Y/14/18/HH

PLAN-022330

16/04/2018

Proposal: Single storey side extension.
Site: 26 Fairholme Drive, Yapton, BN18 0JH.
Y/14/18/HH

BLOCK PLAN

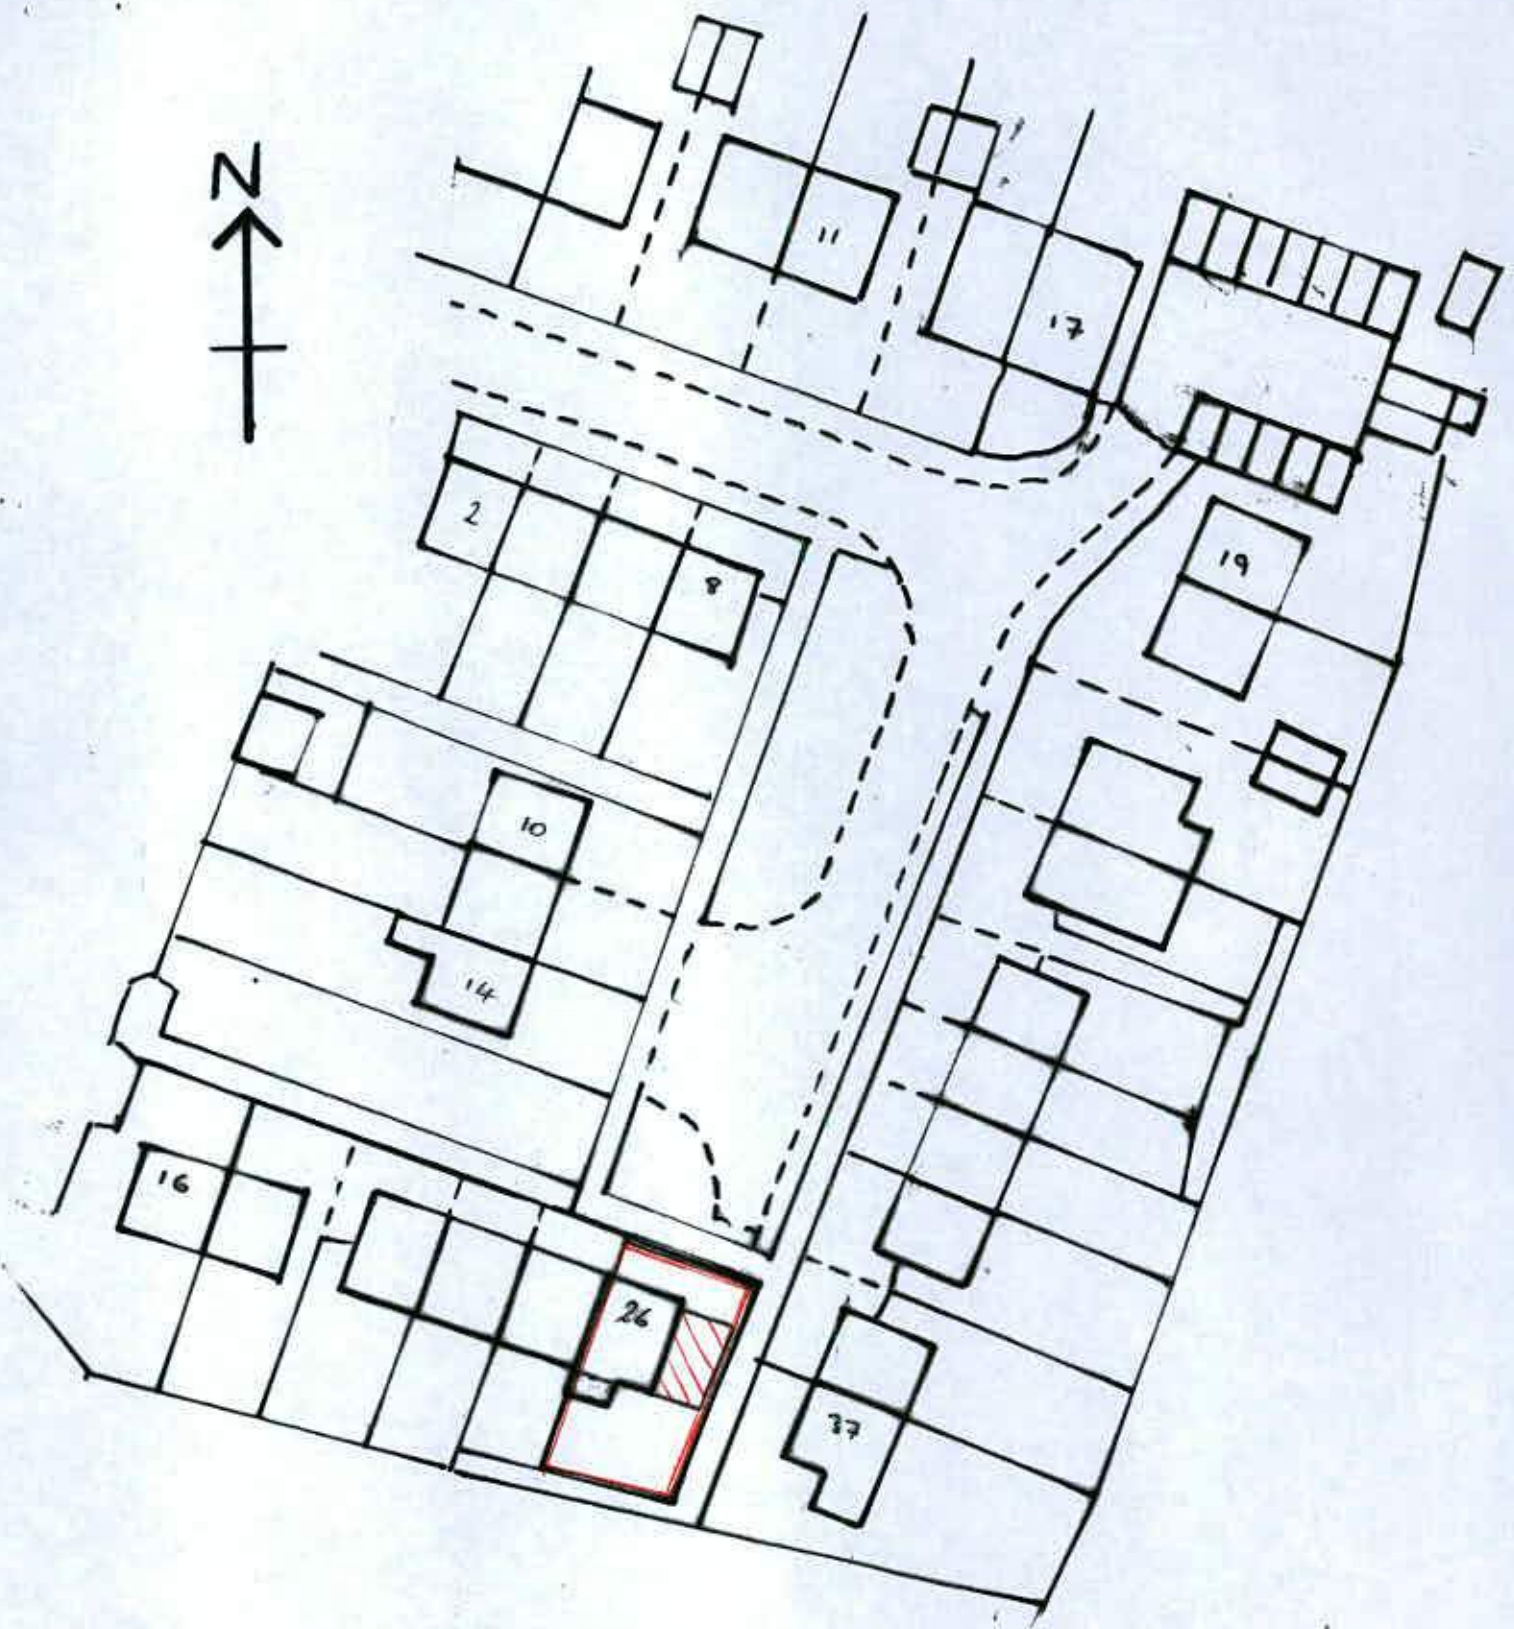
It appears that the developer is intending to build over/close to a public foul sewer which is crossing the site. Building over a "public sewer" is not normally permitted by Southern Water. However, under certain circumstances building over a sewer may be allowed. The conditions associated with the buildover/close to a sewer are contained in Southern Water guidance notes which are available at: www.southernwater.co.uk. A formal application to build close to the sewer will required to be submitted by the applicant.

In order to protect drainage apparatus, Southern Water requests that if consent is granted, a condition is attached to the planning permission. For example "The developer must advise the local authority (in consultation with Southern Water) of the measures which will be undertaken to protect the public sewers, prior to the commencement of the development."
